**From:**  
**Sent:** 25 May 2026 10:43  
**To:** DC Admin  
**Cc:** Louise Bearcroft  
**Subject:** Re planning application 2025/92713

On application 2023/92079 the planning Decision in December 2023 was approval of a Section 106 Outline Permission.

Client PPJ Developments  
 Project 2539 : Moor Lane : Residential  
 Title Proposed Site and Section

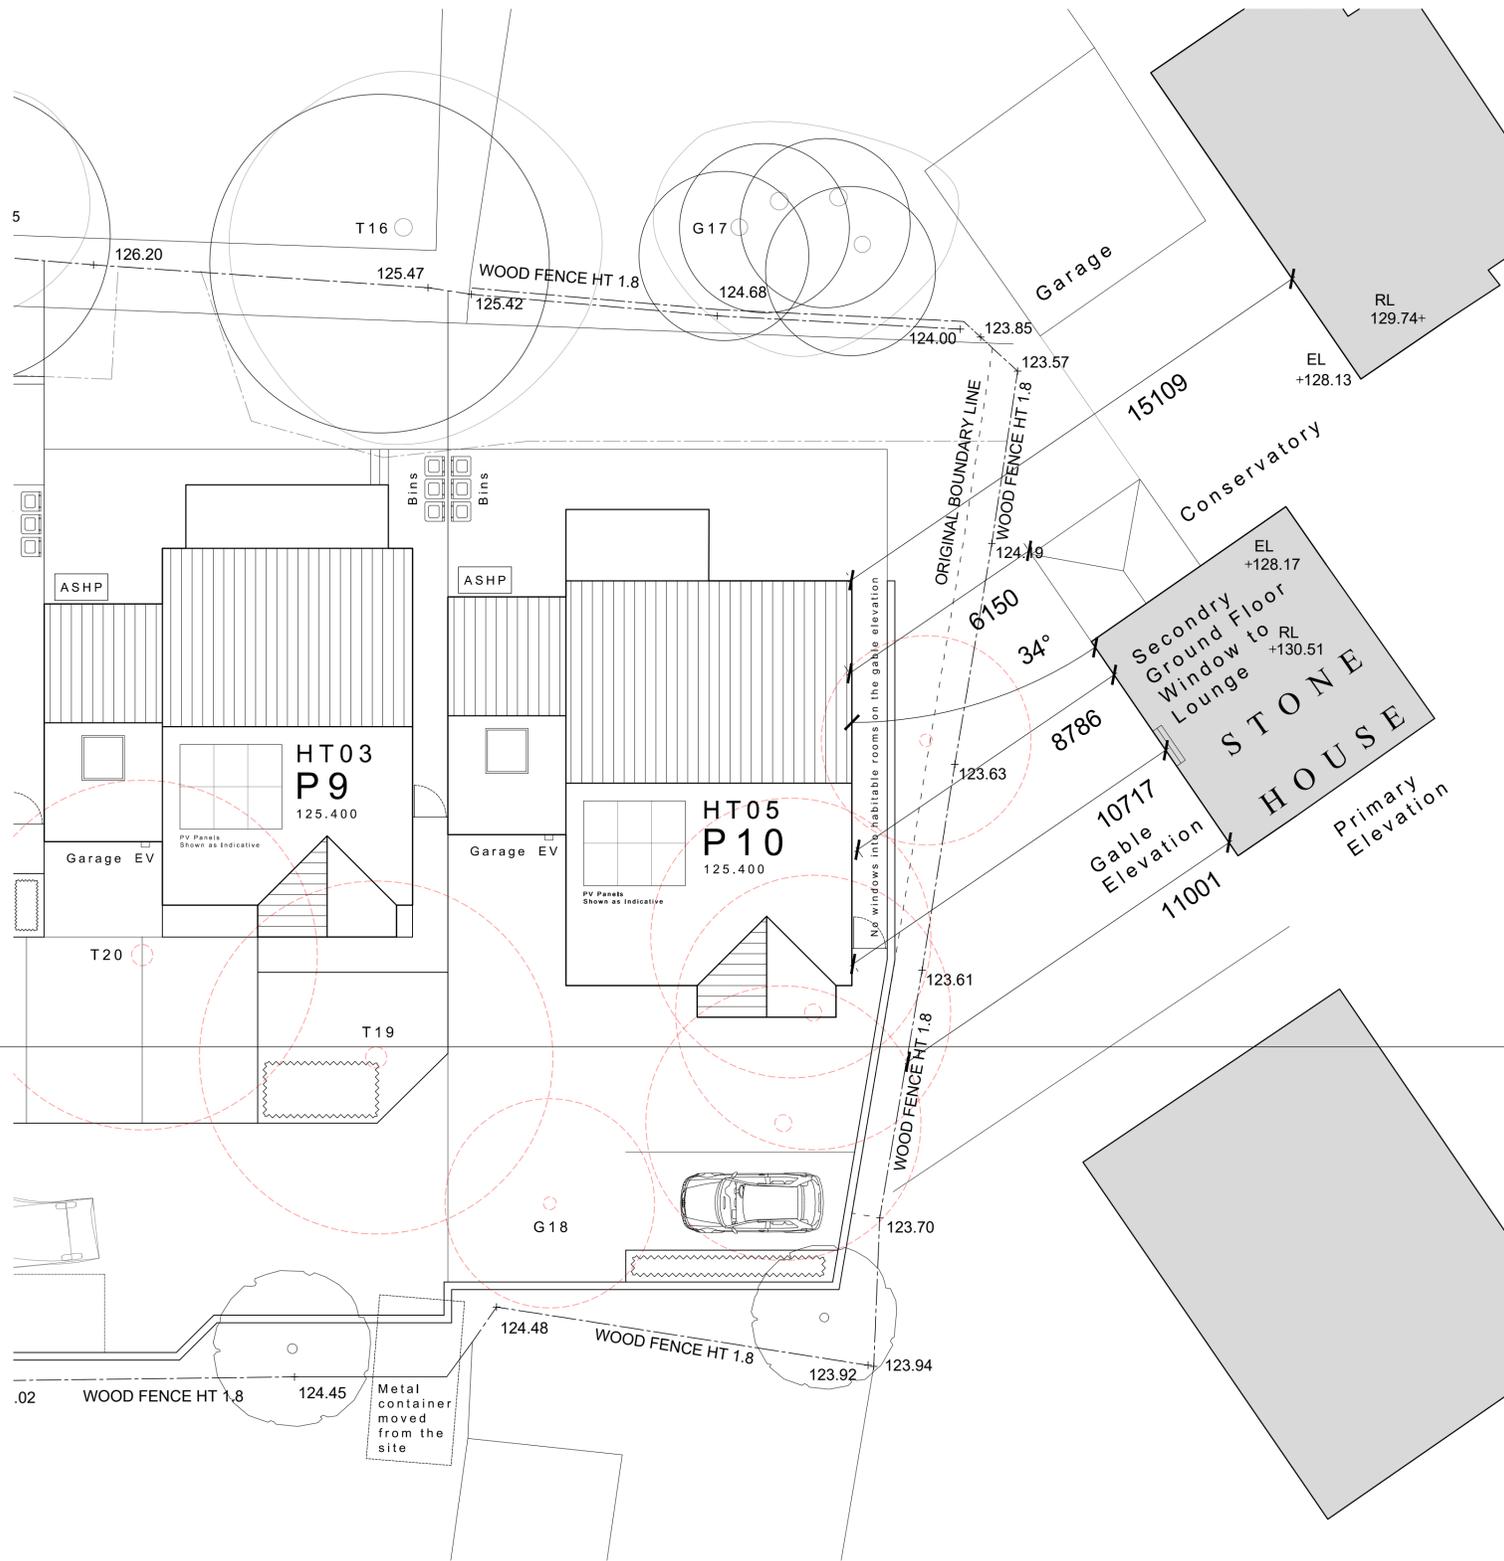
Planning Dept - please reread my objection in comments on application 2025/92713. This is dated 26/3/26, id 1132440. I listed all the section 106 conditions that PPJ had not followed. The only change PPJ have made since 26 March 2026 is there are now 3 visitor parking places shown on recent plans and not 2.

The proposed housing mix is simply too big for the site. If PPJ refuse to accept this and won't revert to the original plan then I urge you to refuse this application.
